Subject: Rezoning Petition Review

Rezoning Petition #: 22-051

Location of Property: Approximately 4.98 acres located on the south side of Sam Neely Rd, west of Steele Creek Rd and east of Krislyn Woods Pl.

CONCEPT PLAN - SF ATTACHED

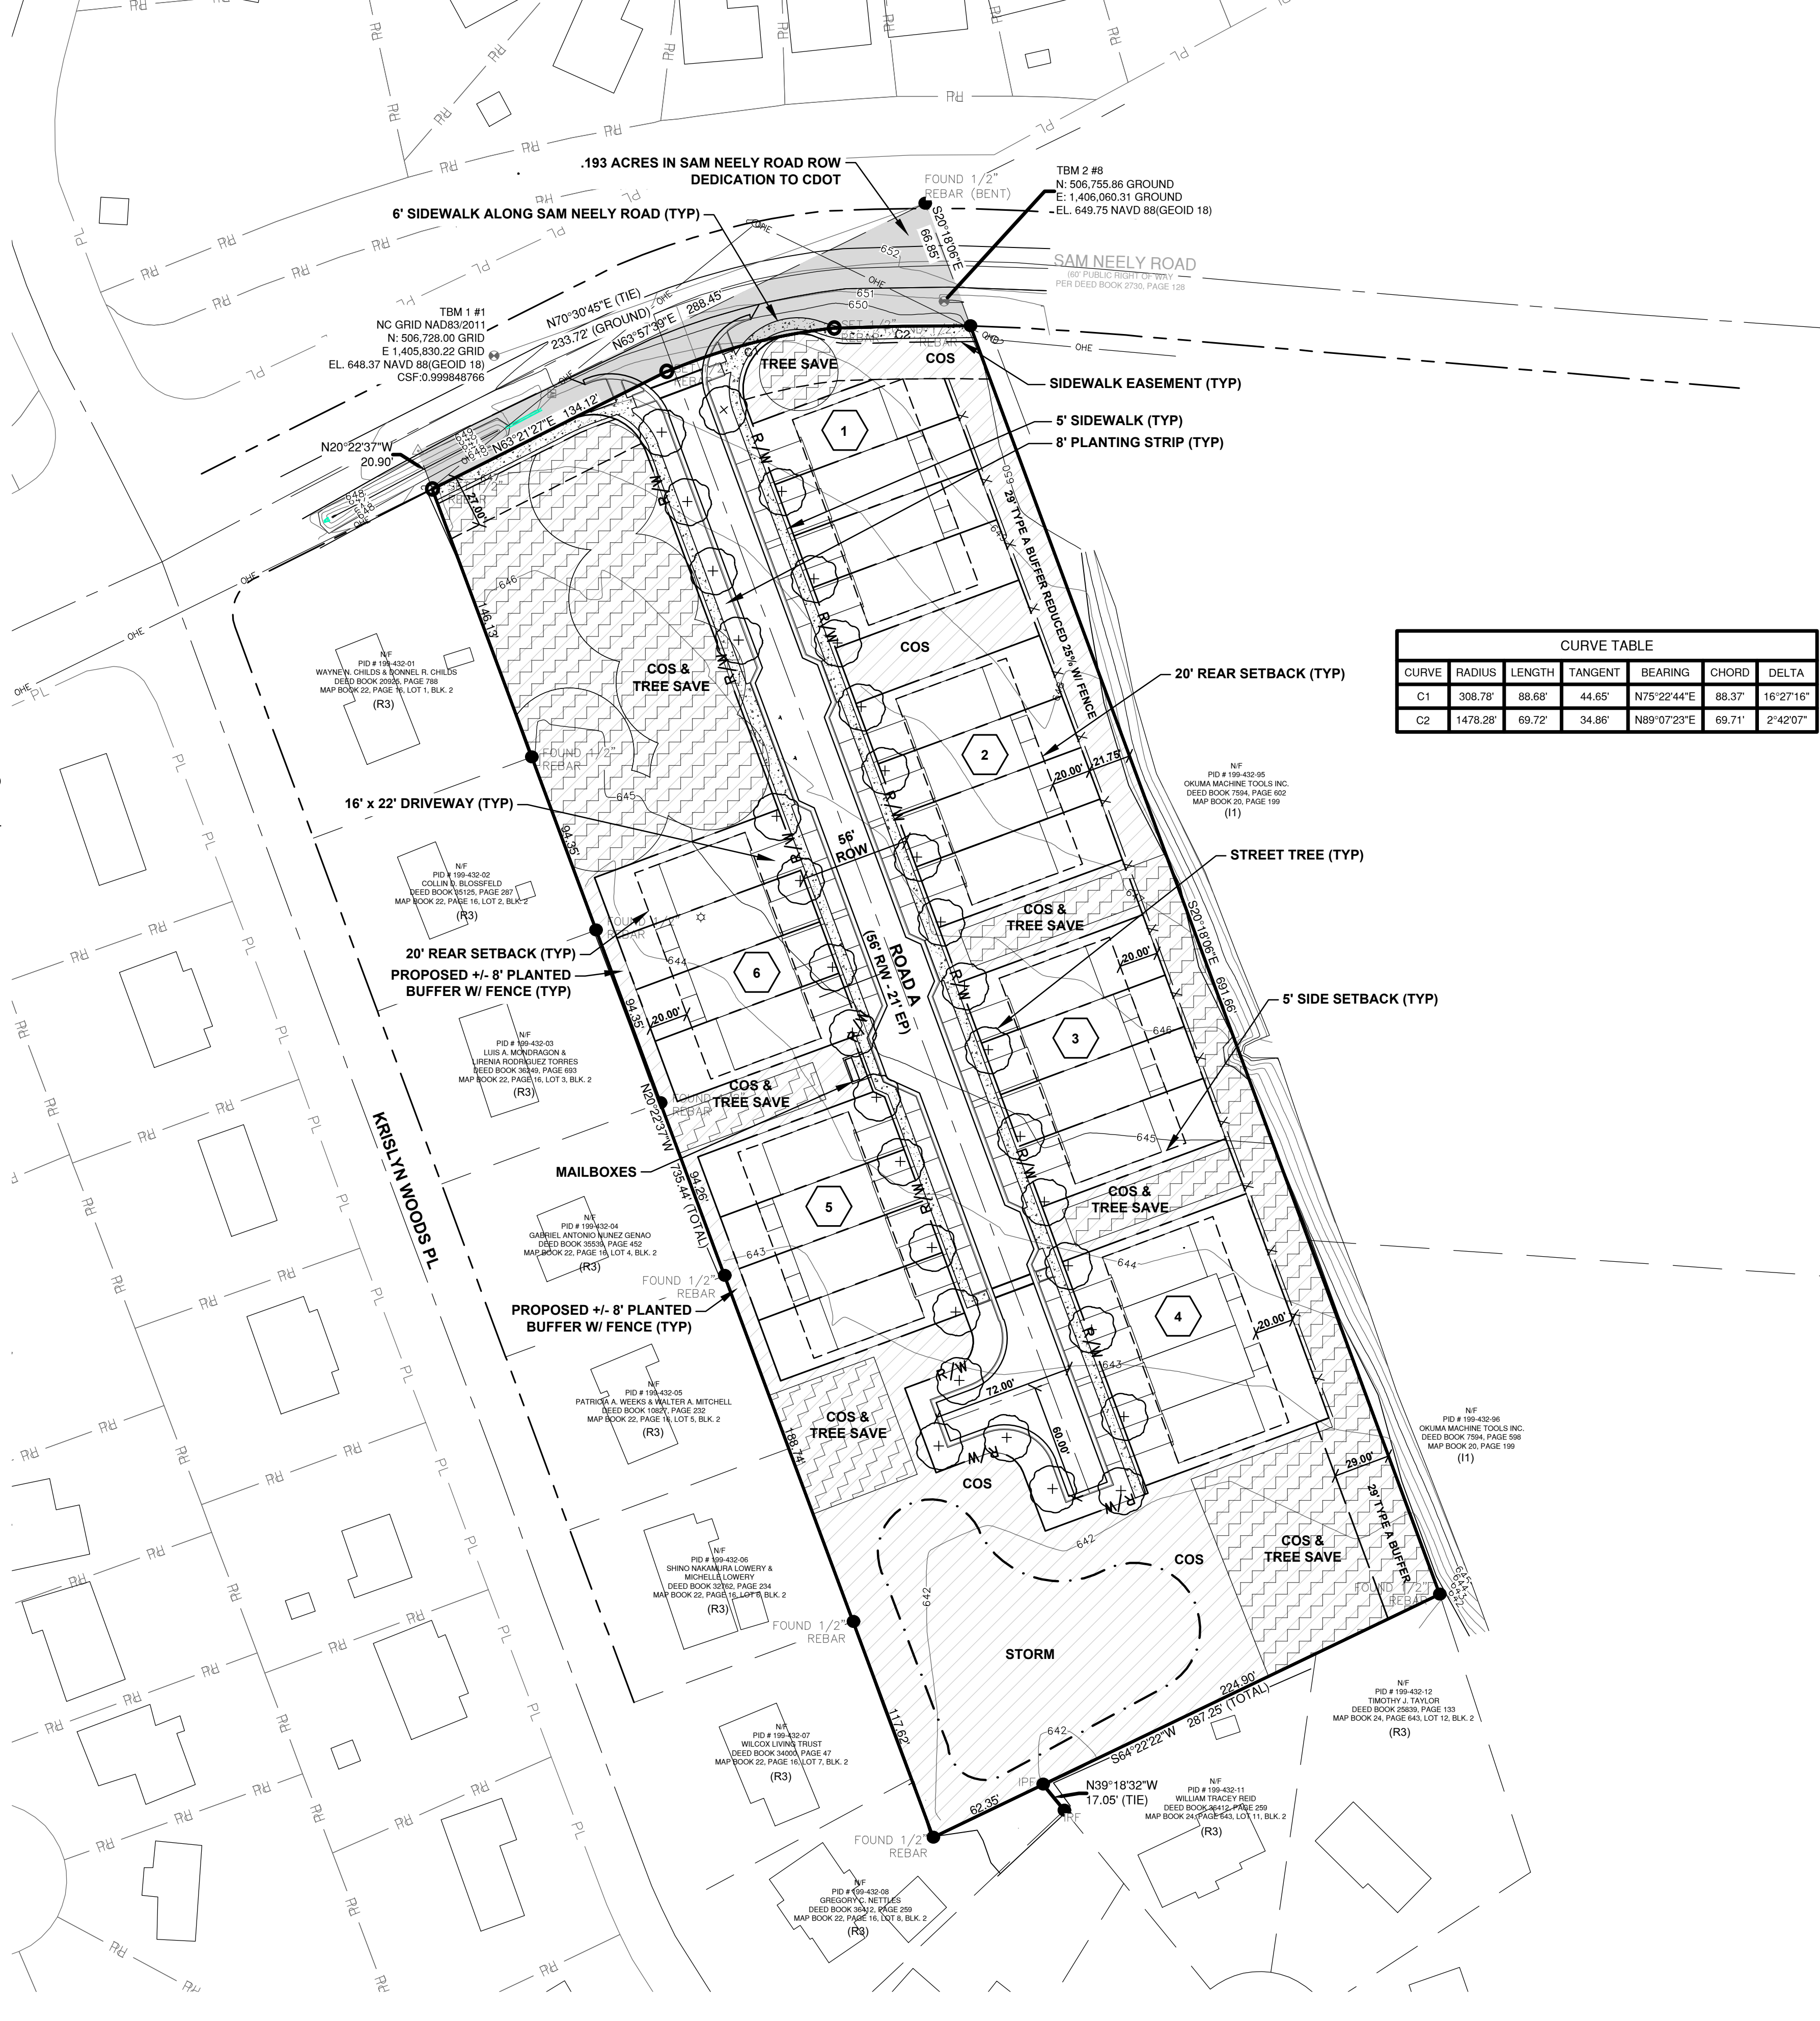
Please add the following note under the *Environmental Notes*: For adjoining parcels receiving stormwater discharge from the proposed BMP/Water Quality feature, the petitioner shall analyze the adequacy of the existing stormwater conveyance on the adjoining parcels. If the existing stormwater conveyance on the adjoining parcels is found to be inadequate, the Petitioner shall make a good faith effort with the property owner(s) to improve the stormwater conveyance or mitigate the stormwater discharge onto the adjoining parcels.

This property drains to Steele Creek, which is an impaired/degraded stream, and may contribute to downstream flooding. This project has the opportunity to mitigate future impacts to this stream, therefore, Storm Water recommends placing the following notes on the plan:

(I) Storm Water Quality Treatment

For defined watersheds greater than 24% built-upon area (BUA), construct water quality stormwater control measures (SCMs) designed for the runoff generated from the first 1-inch of rainfall for all new and redeveloped BUA associated with the project. SCMs must be designed and constructed in accordance with the Charlotte-Mecklenburg BMP Design Manual.

(II) Volume and Peak Control

For defined watersheds greater than 24% built-upon area, control the entire volume for the 1-year, 24-hour storm for all new and redeveloped BUA associated with the project. Runoff volume drawdown time shall be in accordance with the Charlotte-Mecklenburg BMP Design Manual.

For commercial projects with greater than 24% BUA, control the peak to not exceed the predevelopment runoff rates for the 10-yr, 6-hr storm and perform a downstream flood analysis to determine whether additional peak control is needed and if so, for what level of storm frequency, or if a downstream analysis is not performed, control the peak for the 10-yr and 25-yr, 6-hour storms.

For residential projects with greater than 24% BUA, control the peak to not exceed the predevelopment runoff rates for the 10-year and 25-year, 6-hour storms or perform a downstream analysis to determine whether peak control is needed, and if so, for what level of storm frequency.
